July 2, 2020

Re: CAO15-001 & VAR18-002

### EXCERPTS FROM PRIOR WRITTEN COMMENTS MADE BY DAVID L. ANDERSON TO EVAN MAXIM

A PORTION OF GOVERNMENT LOT 3, OF SECTION 19, TOWNSHIP 24 NORTH, RANGE 5 EAST, W.M., KING COUNTY, WASHINGTON

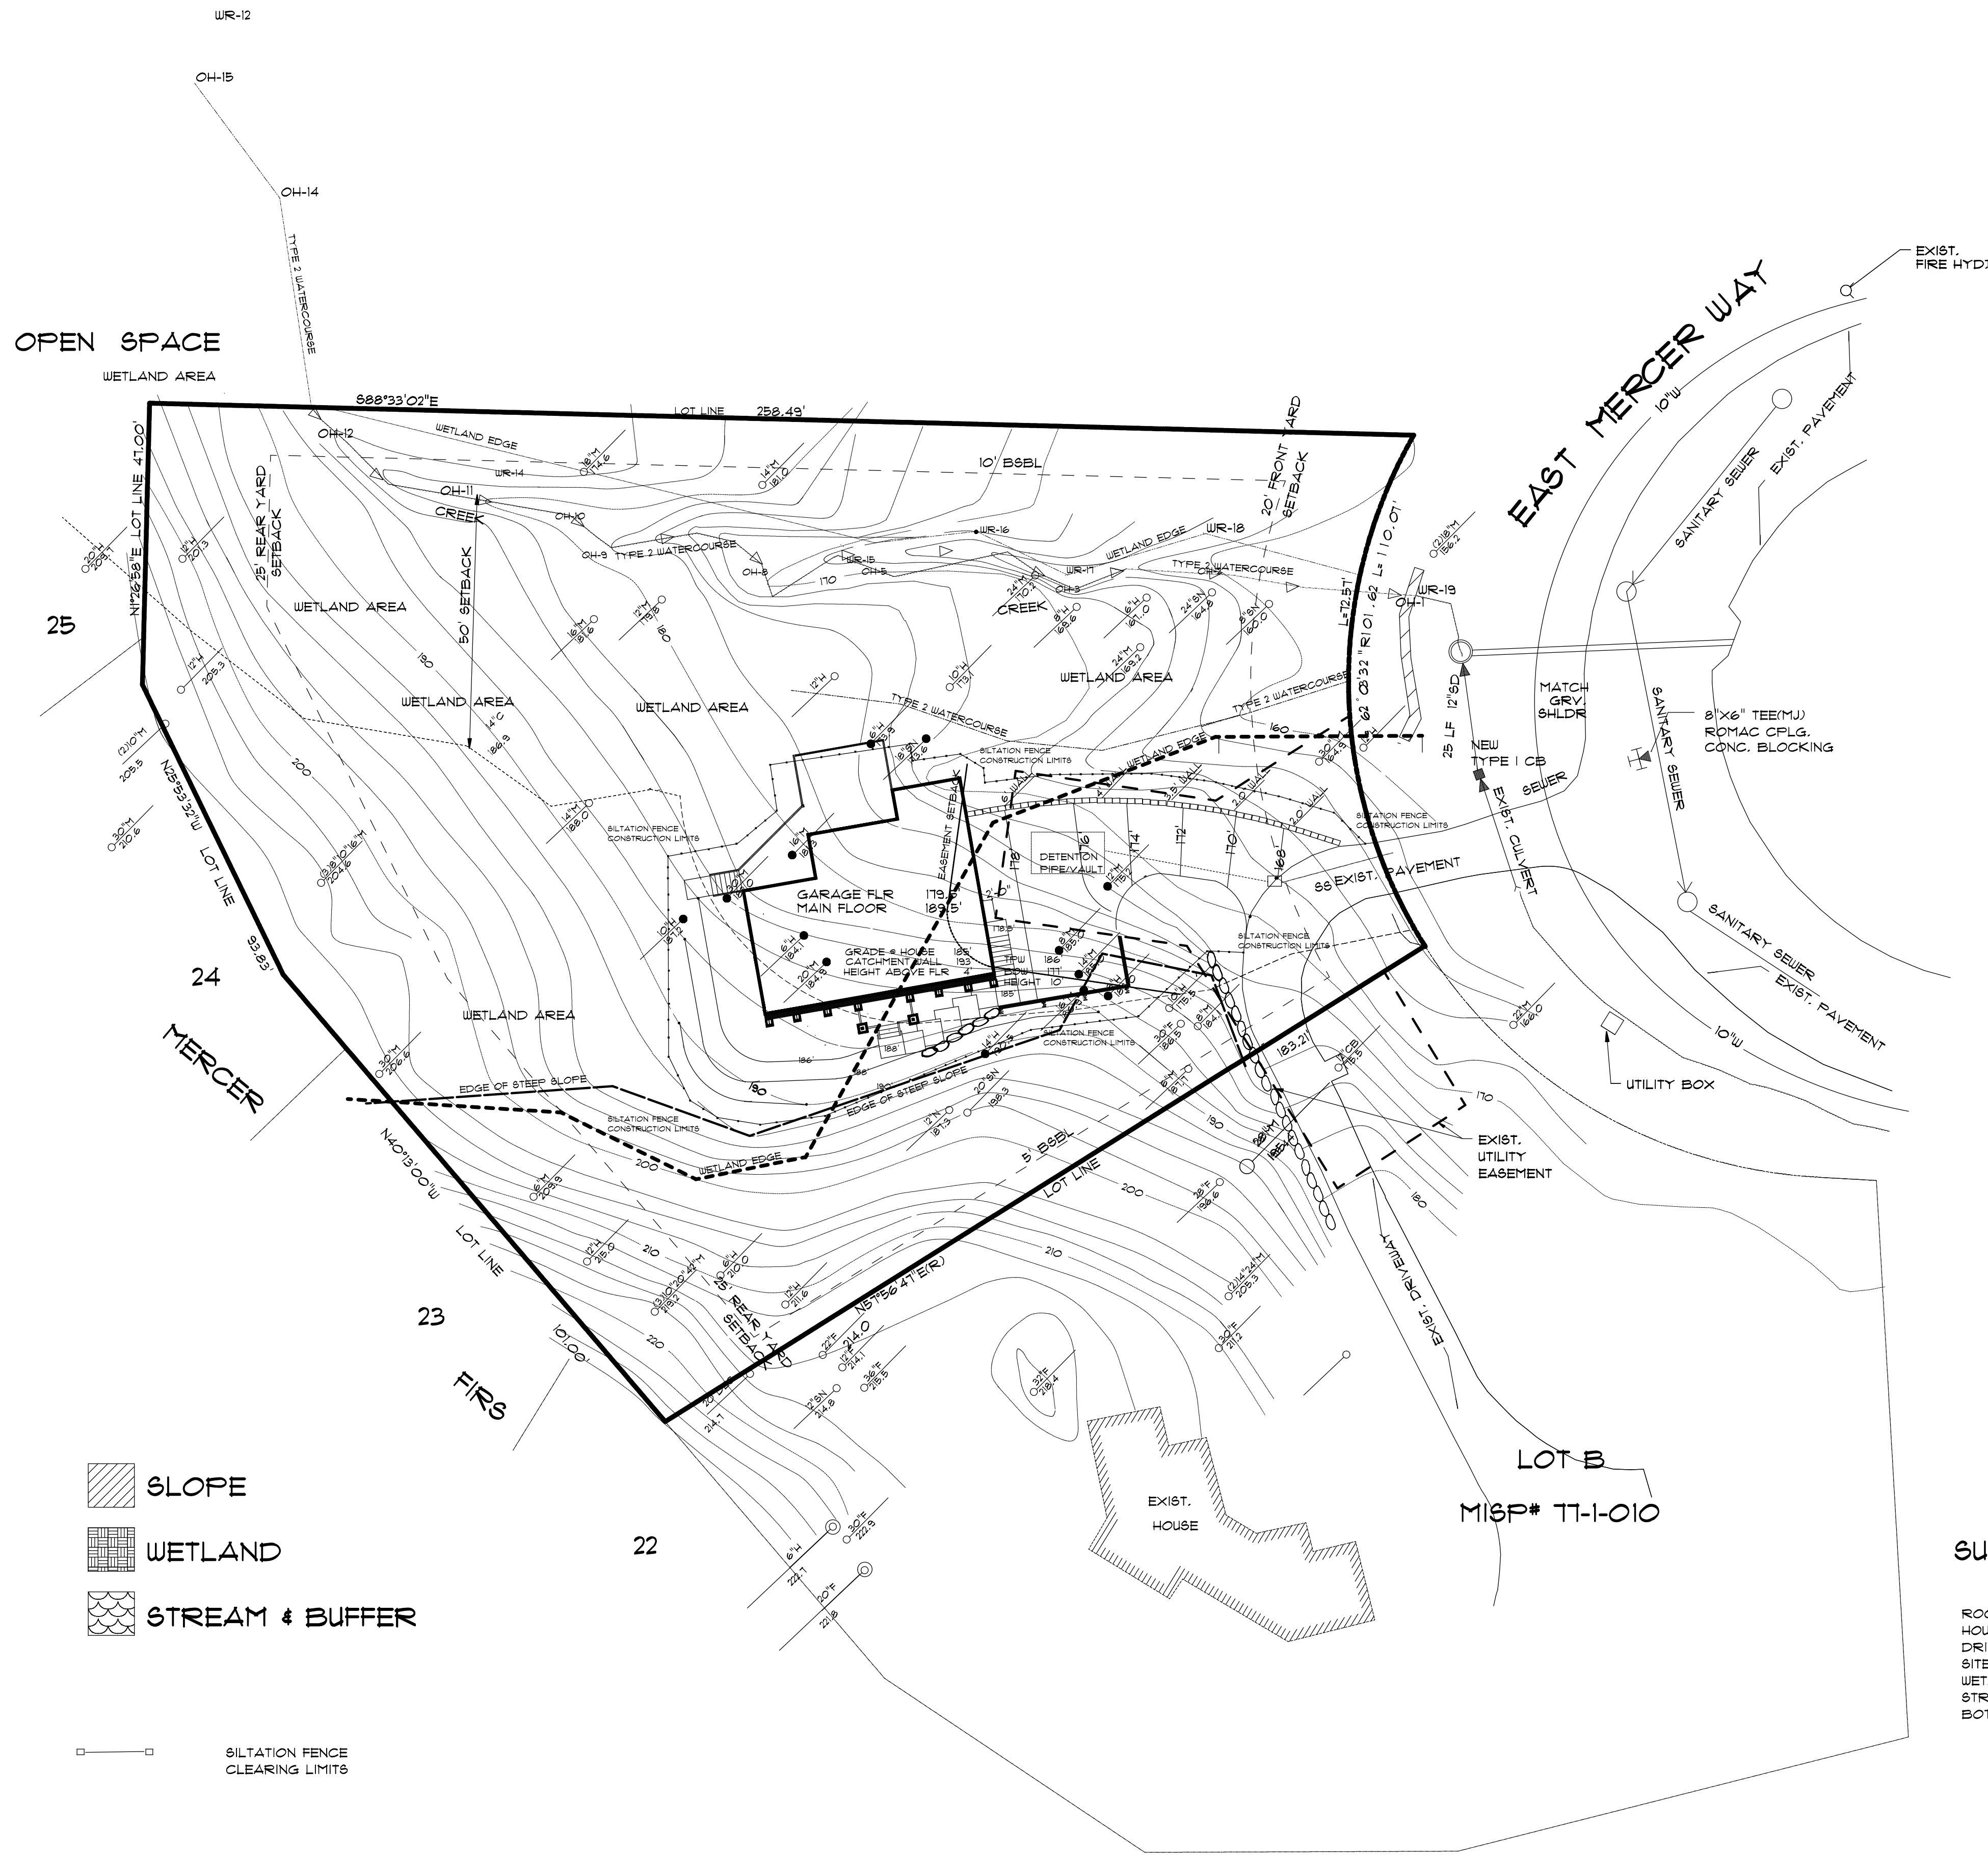
The statement that the SEPA submittal and RUE application “*materials are not entirely as detailed*” does not accurately represent what has been provided by MI Treehouse. Details aside, the revised site plan does not include any schematic drainage plan or the proposed discharge locations. The vault and any references to the proposed storm drainage system have been removed from the updated plan. There is no reference whatsoever to the retaining wall drainage, perforated drainage for the proposed detention vault, and any foundation drainage in either the plan or the SEPA checklist. The written responses in the SEPA checklist are limited to vague one-sentence responses. The proposed project is located within a wetland, within water course buffers, and in an area where there has been downstream drainage issues in the past. How can we be expected to provide any meaningful review or comment on the proposal without any information on these drainage systems?

The location of the stormwater detention storage tank could also impact the existing wetland area beyond what is shown in the revised 2018 plan. The tank identified in the preliminary calculations included a 17.45' by 17.45' footprint with a 5' depth. The tank would typically need at least 2' of cover from the lowest surface elevation to allow for installation of the driveway and to provide cover for the associated storm drainage conveyance piping that connects the development area to the detention storage. The tank installation would typically include granular bedding and backfill materials. As the excavation would boarder a wetland, the area would need to be de-watered to install the tank. The granular bedding and backfill would typically include a perforated drain to provide the required de-watering and to eliminate potential buoyancy of the tank. This drain could be in the range of 8' below the driveway elevation further impacting the down-gradient wetland area and flow into the adjacent water course on a permanent basis.

Please note the location of the southern watercourse has changed on the more recent plans from previous site plans. The 2018 plan shows the southern watercourse shifted to the north further away from the proposed building site and from the low area as designated by the contour lines. If the revised location for the watercourse is correct it would appear that the topography in this area may need to be adjusted on the plan. If the topography is correct, then the watercourse location should be more thoroughly confirmed and could conflict with the proposed building location.

The proposed development includes a retaining wall on south and west of the proposed building location. With the garage floor elevation of 179.5 the bottom of the wall would typically be below 178 which is approximately 10 feet below the existing grade at the southwest corner of the house. The retaining wall will typically require permeable materials behind the wall with drainage collection at the base of the wall and around the structure foundation or slab. With a perforated drain approximately 10 feet below the surface there will almost certainly be a permanent impact on the existing wetland areas south, west, and potentially northwest of the proposed building location. A portion of this area is indicated on the 2018 site plan as temporary wetland disturbance due to grading activities. The wall construction with drainage collection 10 feet below the wetland surface will permanently impact the wetland area and could de-water a significant portion of the up-gradient wetland areas potentially including those that extend beyond the parcel limits.

The location of the stormwater detention storage tank could also impact the existing wetland area beyond what is shown in the revised 2018 plan. The tank identified in the preliminary calculations included a 17.45' by 17.45' footprint with a 5' depth. The tank would typically need at least 2' of cover from the lowest surface elevation to allow for installation of the driveway and to provide cover for the associated storm drainage conveyance piping that connects the development area to the detention storage. The tank installation would typically include granular bedding and backfill materials. As the excavation would border a wetland, the area would need to be de-watered to install the tank. The granular bedding and backfill would typically include a perforated drain to provide the required de-watering and to eliminate potential buoyancy of the tank. This drain could be in the range of 8' below the driveway elevation further impacting the down-gradient wetland area and flow into the adjacent water course on a permanent basis.
